April 17, 2020

RE: Grandview Reserve  
El Paso County, Colorado  
Master Traffic Impact Analysis  
LSC #184840

GRANDVIEW RESERVE SKETCH PLAN
 SKETCH PLAN

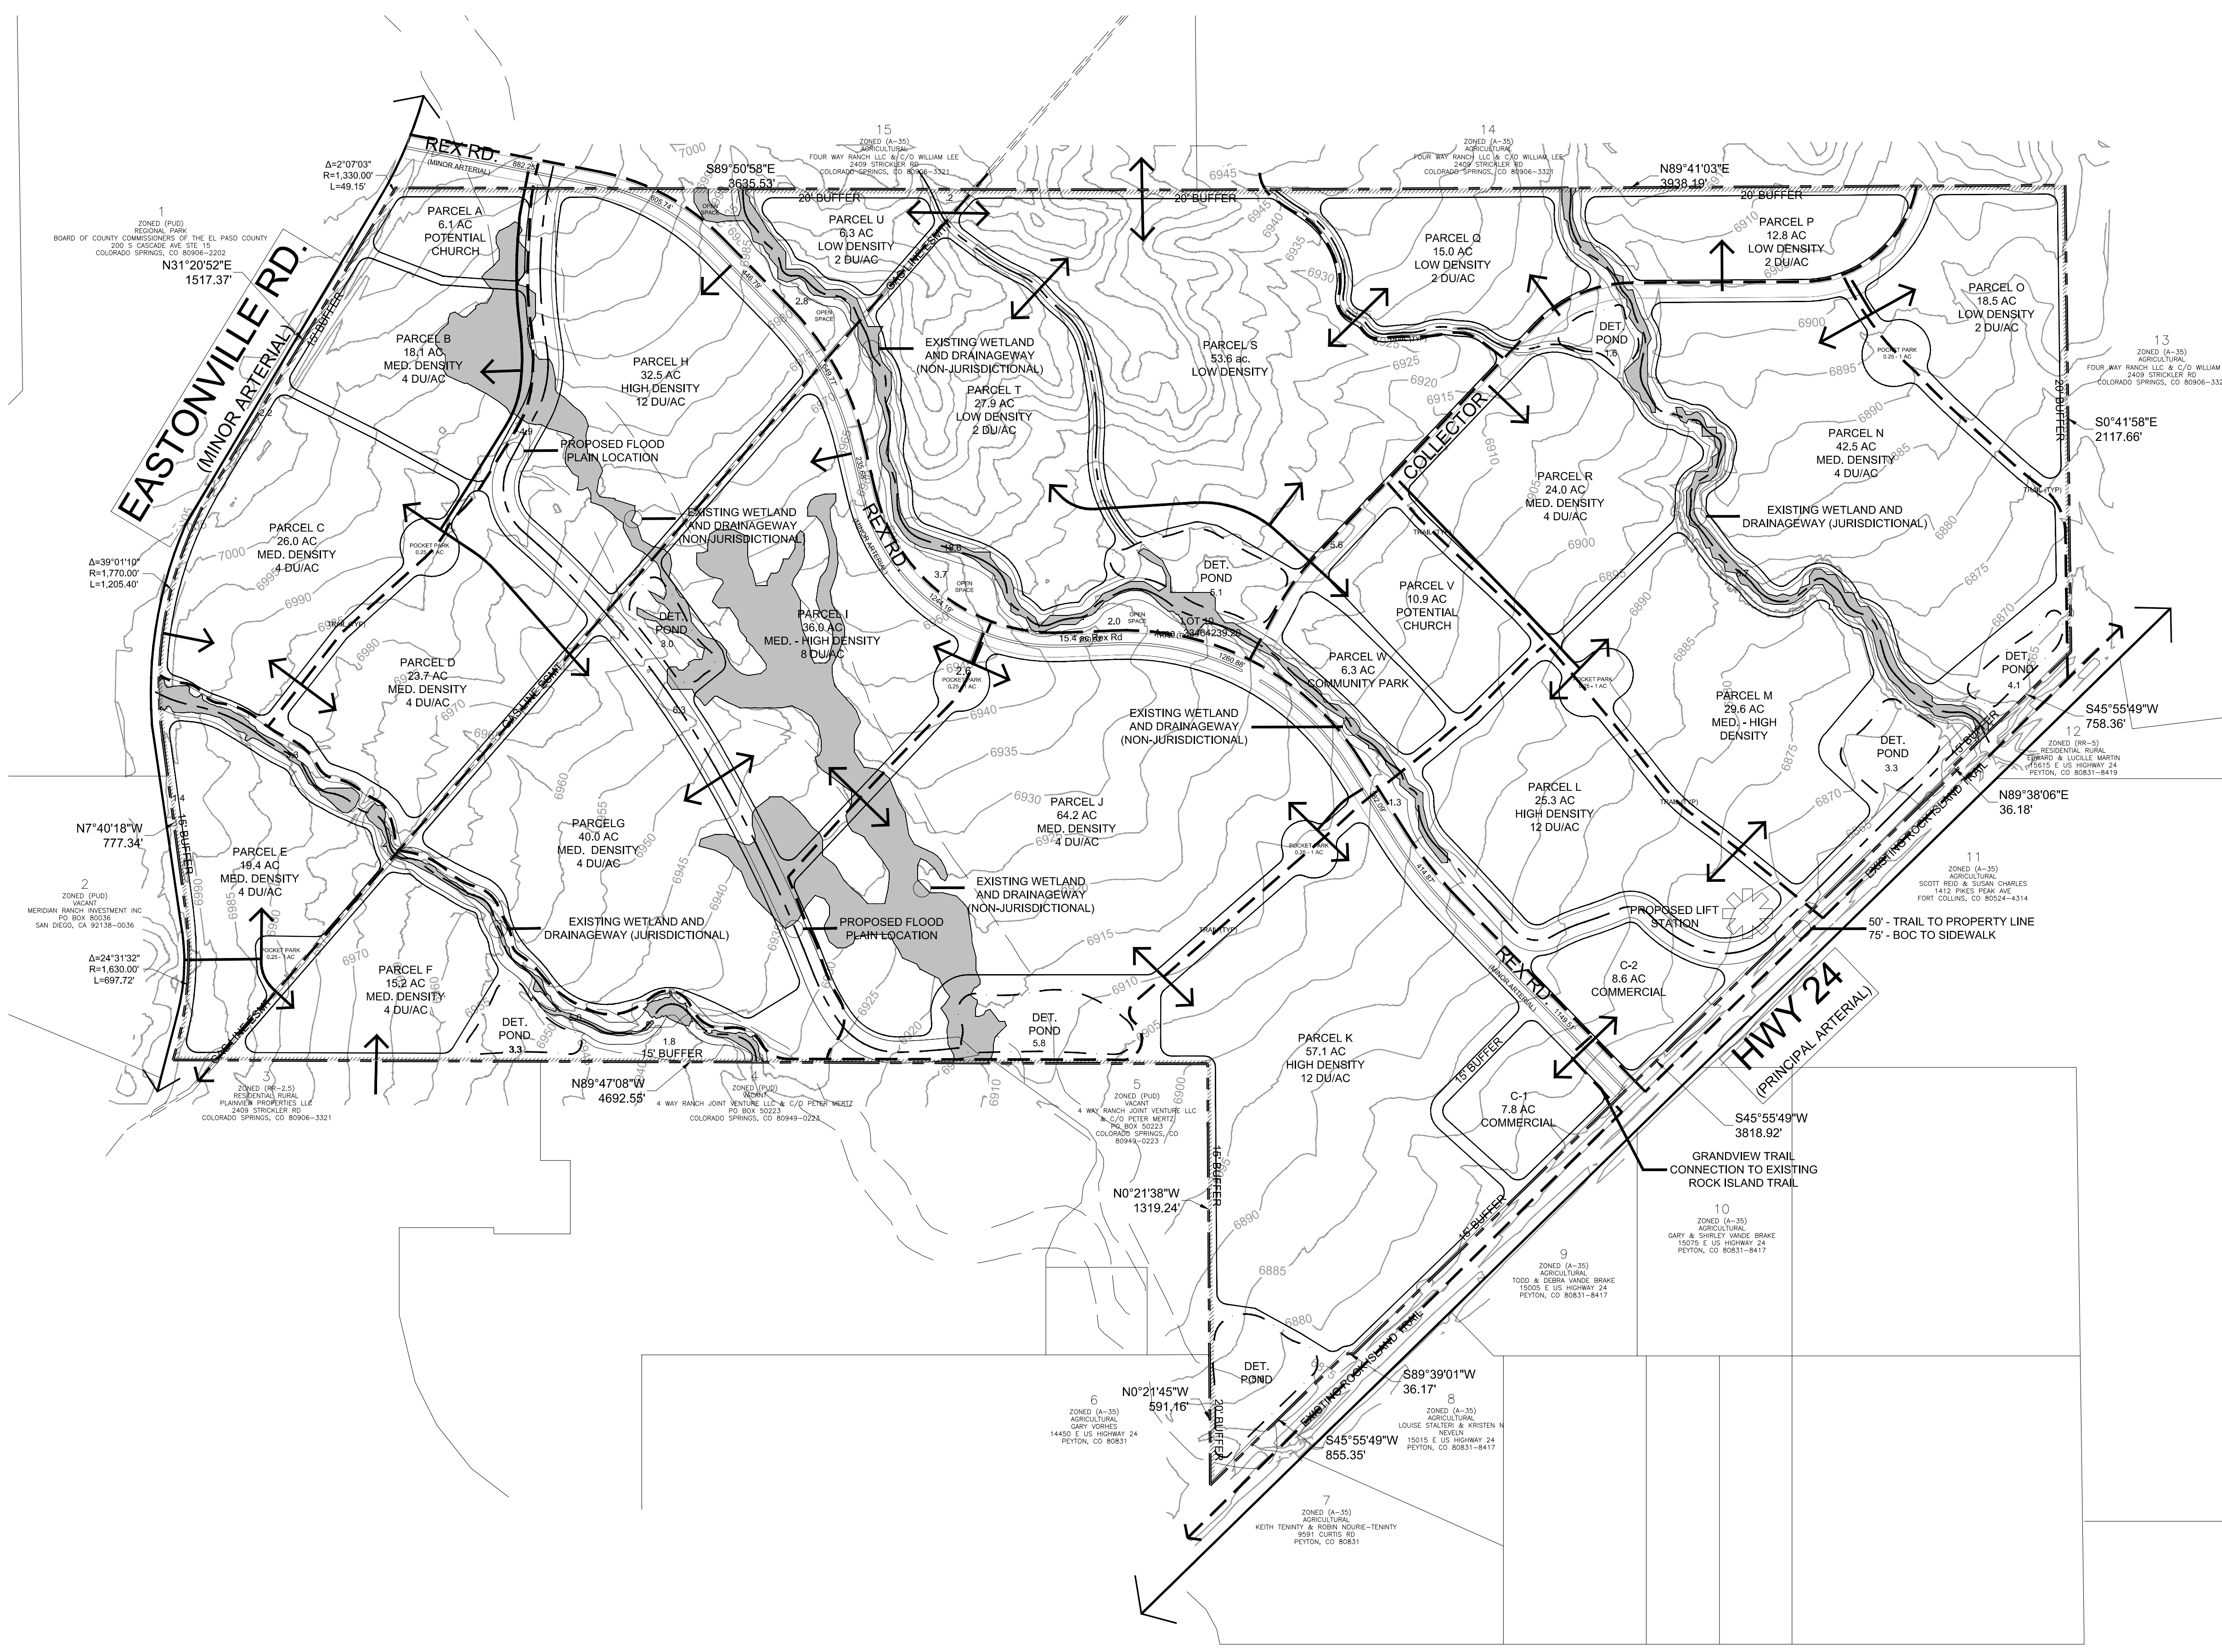
The site access points to Rex Road and Eastonville Road will need to meet County standards for intersection and stopping sight distance.

The roads and access points shown on the Sketch Plan are conceptual and may change during the subdivision process.
